CITY OF ALBUQUERQUE

RE: Palisades Subdivision, Replat of Block 4, Lots P-1, Q-1, R-1 #<u>J11-D009</u>

(DRB Case # 10009710)

Conceptual Grading and Drainage Plan for RePlat

DRAINAGE REPORT &
BASIN MAP

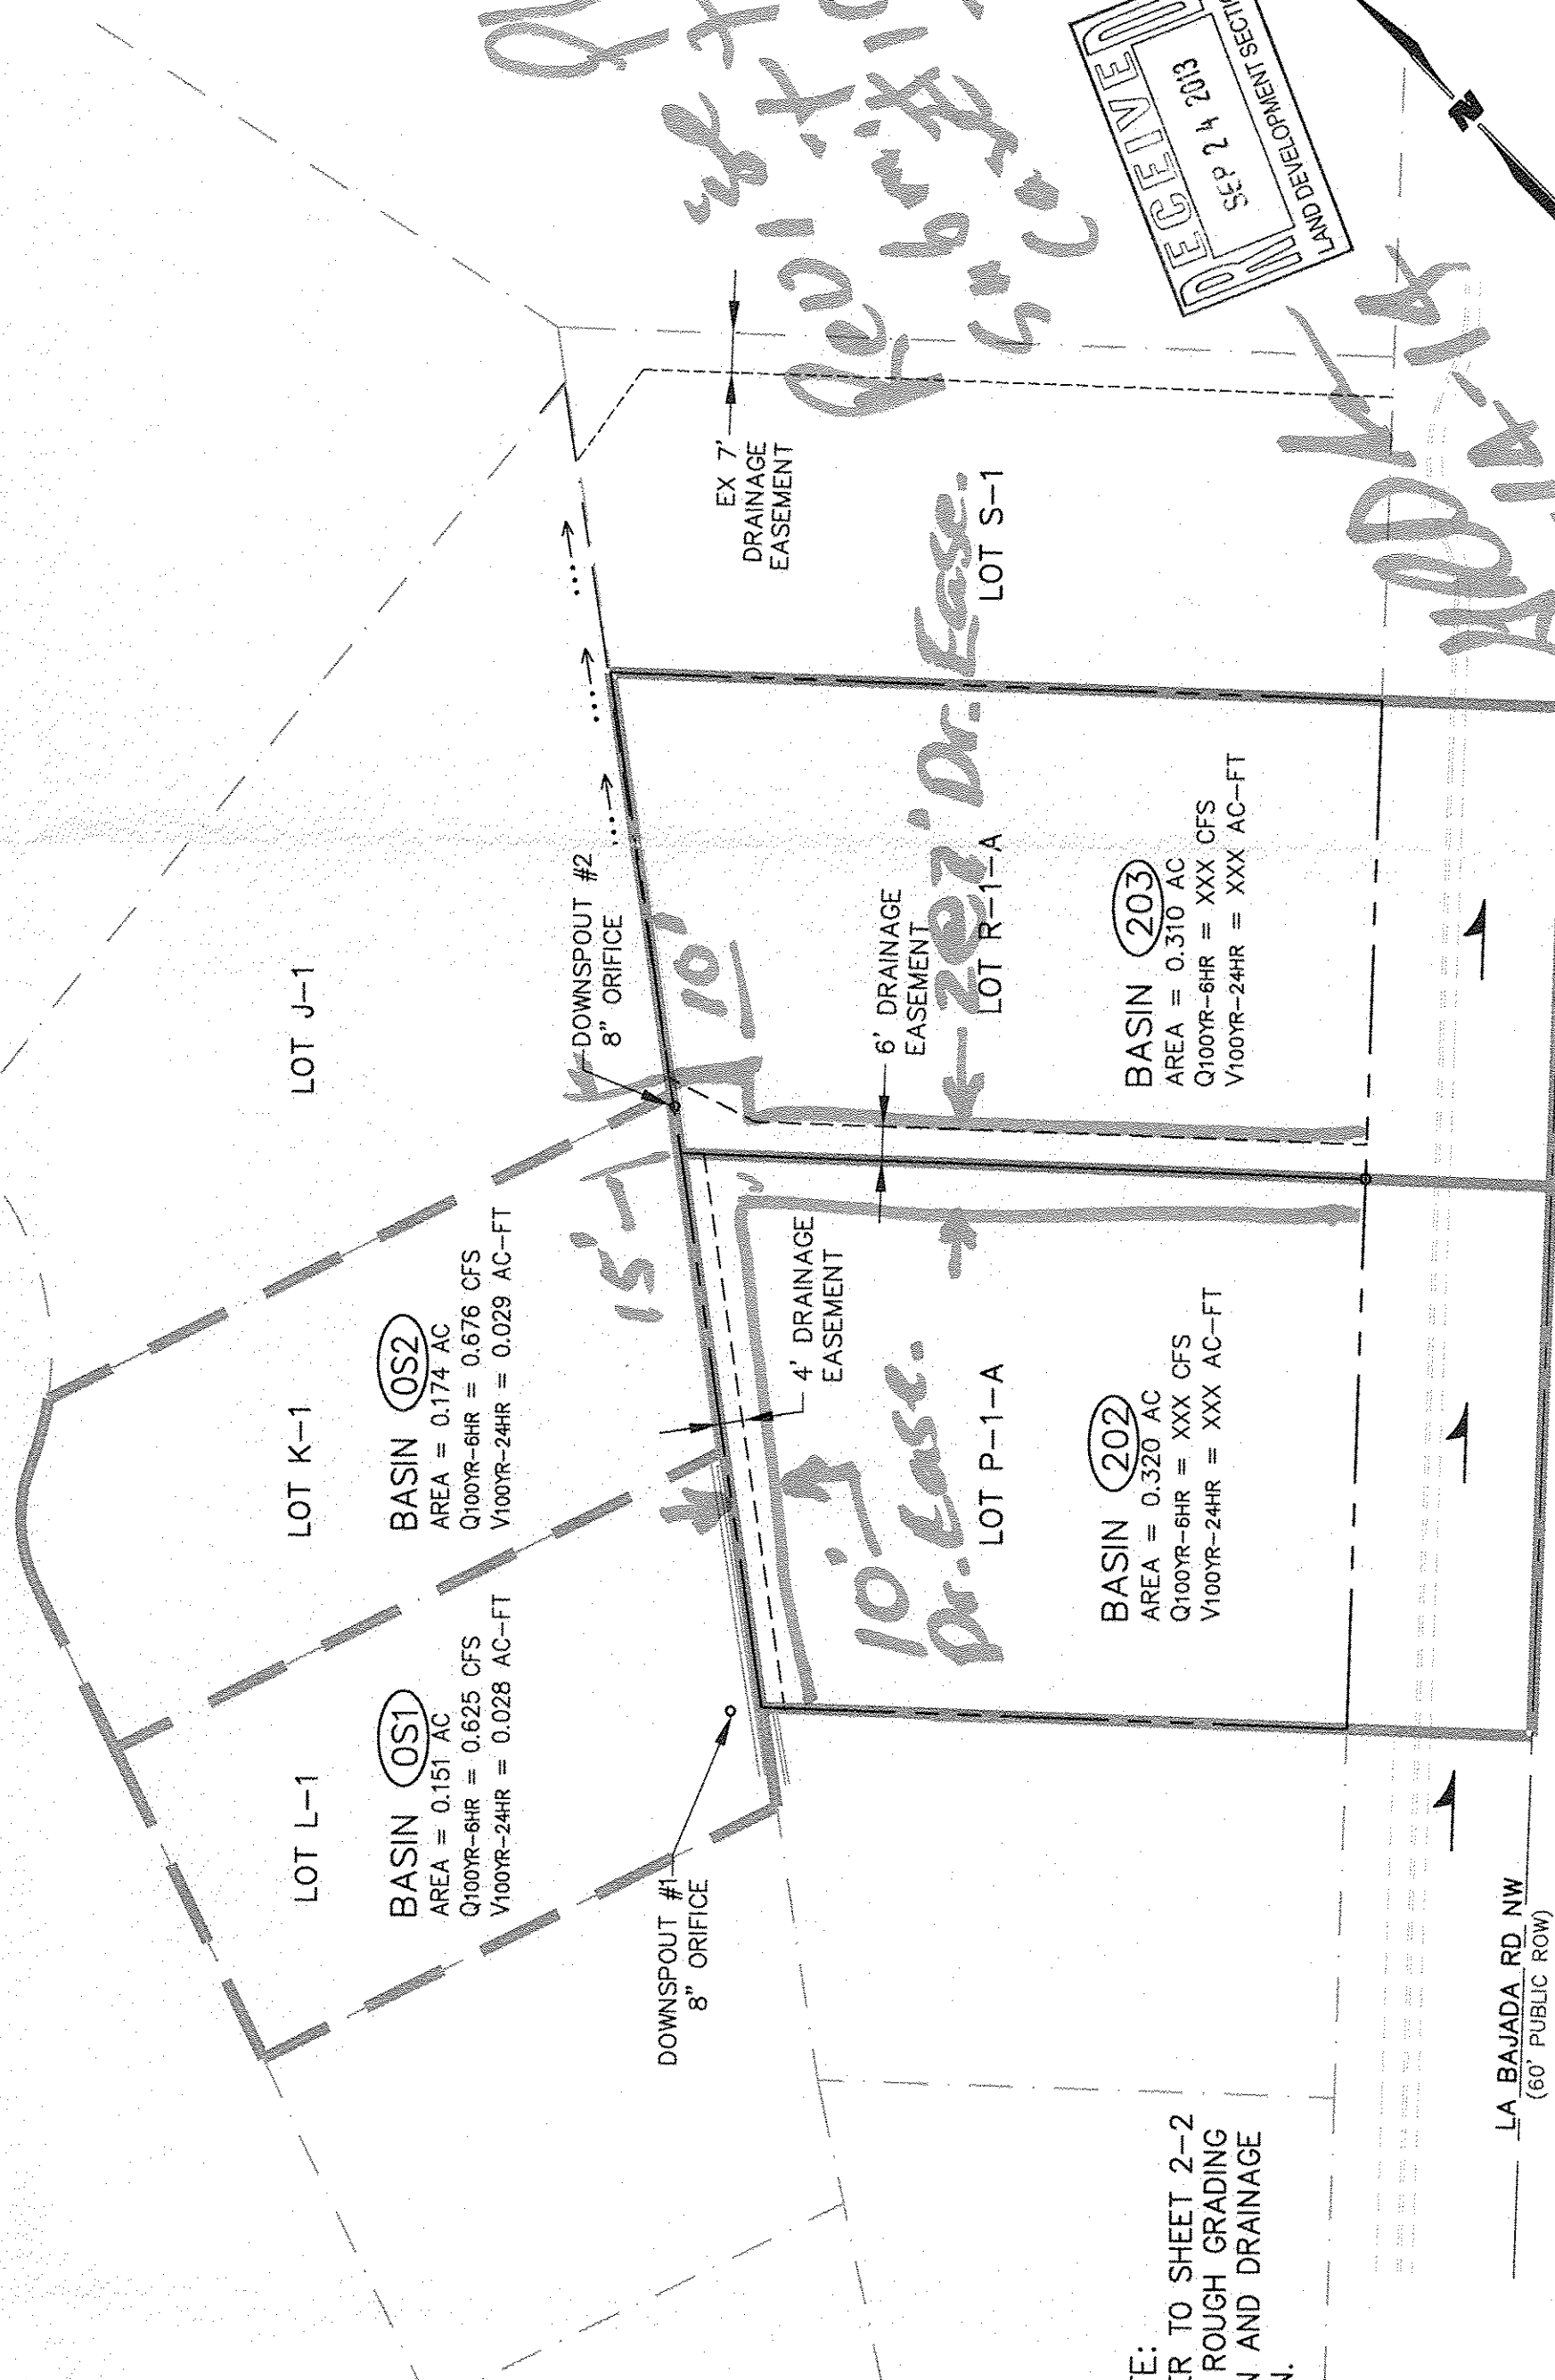
Based upon the information provided in your submittal received on 9/24/13, and my subsequent conversations with you and the owner, Chris Sanchez, the above **referenced Conceptual Grading Plan cannot be approved for Platting action**. The extreme grade differential on these lots creates significant concern for the buildability of the proposed lots, as well as the stability of existing, adjacent structures.

1. The proposed drainage easements must be revised to convey upstream flows through the new lots, SE to La Bajada Street R/W, without crossing the property line to the adjacent lot.

- 2. Mr. Sanchez indicated to me that he does not intend to do site grading and retaining wall construction for the platted area. Hence, the drainage concept for the proposed lots needs to demonstrate that the new lots will be buildable, individually.
- The existing survey does not provide offsite grades on the west and south edges of the site, preventing review of impacts on adjacent sites and structures. Per the DPM, this plan should provide offsite grades for 25' beyond the property lines.
- 4. The drainage concept must also recognize zoning restrictions on maximum wall heights allowed, and Special Exception criteria applicable with excess heights.

5. A major concern is the feasibility (structural & economic) of constructing the proposed retaining wall at the rear lot line, cutting as much as 10-feet below the foundation of the existing retaining walls at the back of the abutting lots. Related to this concern is the proposed 4' wide drainage easement at the base of that wall, conveying runoff, laterally along the top of a 1:1 slope. Any slope over 3:1 requires erosion protection per the DPM. The light, sandy soil on this site may need to be as flat as 5:1 to avoid erosion without protection. It seems more appropriate to proposed terraced retaining walls, offset from the existing retaining walls, to ensure the stability of those structures.

1. On proposed lot P-1-A, provide a 10-foot Drainage Easement along the back, NW side of the lot, and a 7-wide Drainage Easement along the, NE side of the lot, for the benefit of Lots L-1 and K-1, to drain to the La Bajada Road R/W.

2. On proposed lot R-1-A, provide a 10-foot wide by 15-foot long Drainage Easement at the back, SW corner of the lot, and a 7-wide Drainage Easement along the NE side of the lot, for the benefit of Lot K-1 to drain to La Bajada.
